**Re: PA22-044 – Olympic Vista PRD – Technical Review 2**  
4128 Sunnyside Blvd. APN 29050300102200

SUBJECT: PA 22-044 – Olympic Vista PRD, Technical Review #2

JOB NUMBER: C21-210
 DRAWING NAME: C21210PP-PP-PL
 DESIGNER: TPA
 DRAFTING BY: BJN
 DATE: 2-07-23
 SCALE: 1"=40'
 JURISDICTION: MARYSVILLE

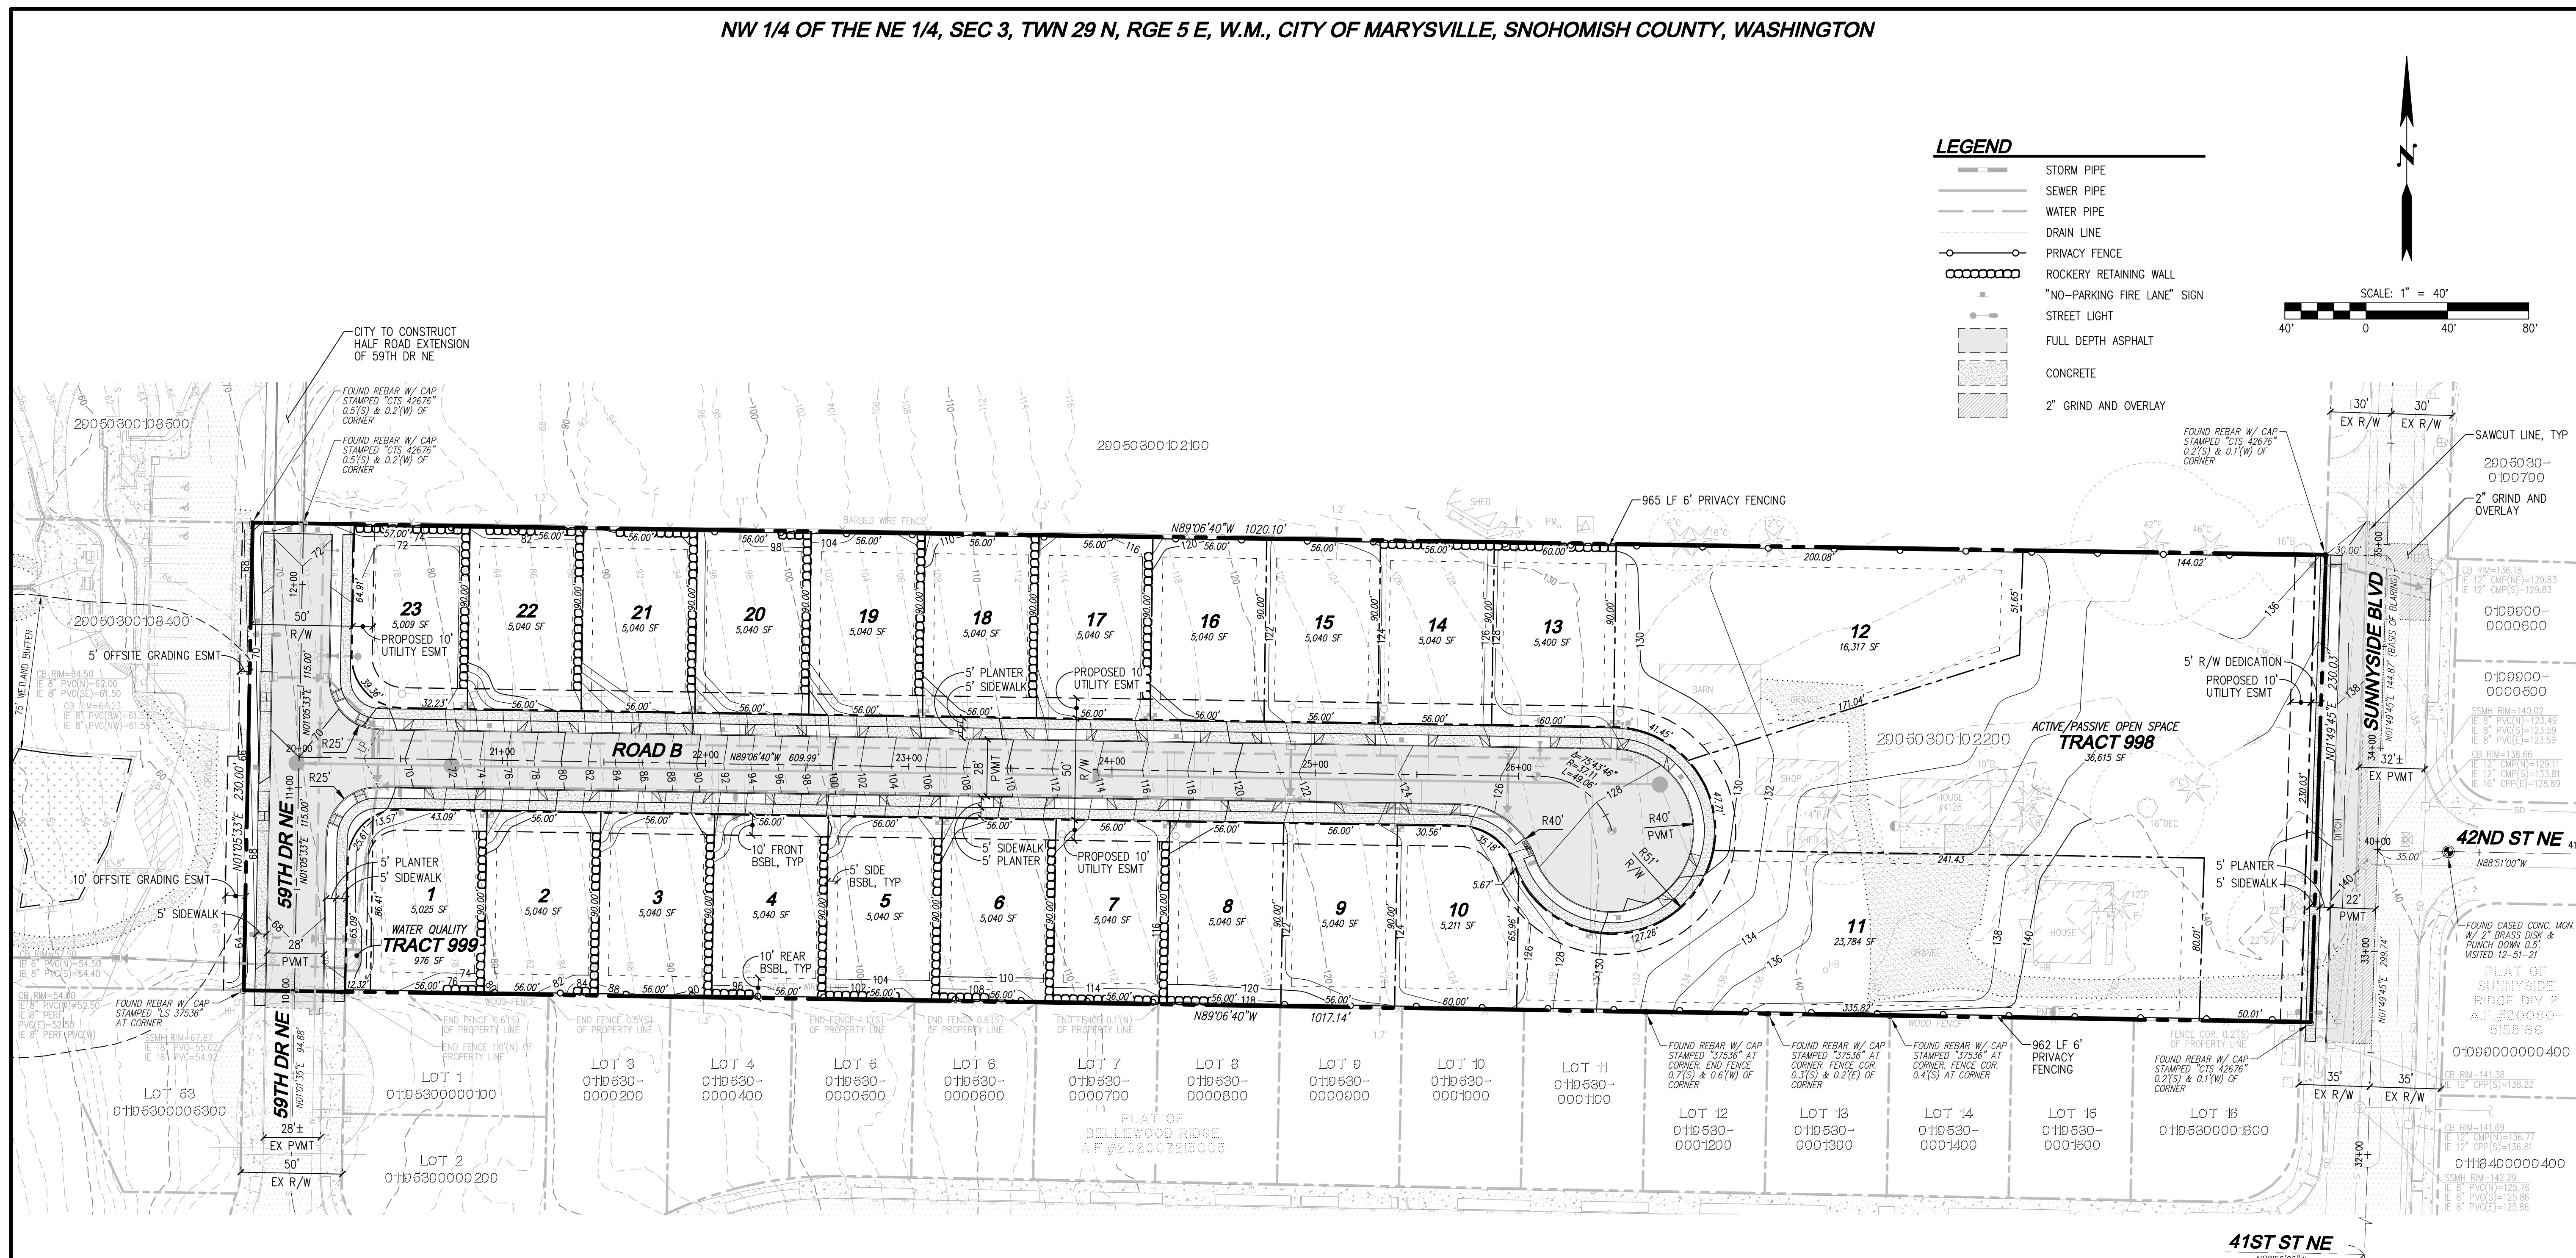
2. According to the Open Space Calculations table on sheet 2, required open space is 0.64 acres (27,843 SF) and total open space provided is only 0.42 acres (18,457 SF). Please revise the table on the site plan to accurately display open space quantities.

1. Pursuant to MMC 22D.050.030(4)(e), retaining walls taller than four feet and are visible from the street **or adjacent property** shall be terraced so that no individual segment is taller than four feet. This is anticipated to be a condition of preliminary approval. Compliance will be verified during civil construction plan review.

**Tall retaining walls must be terraced with landscaping as depicted below.**
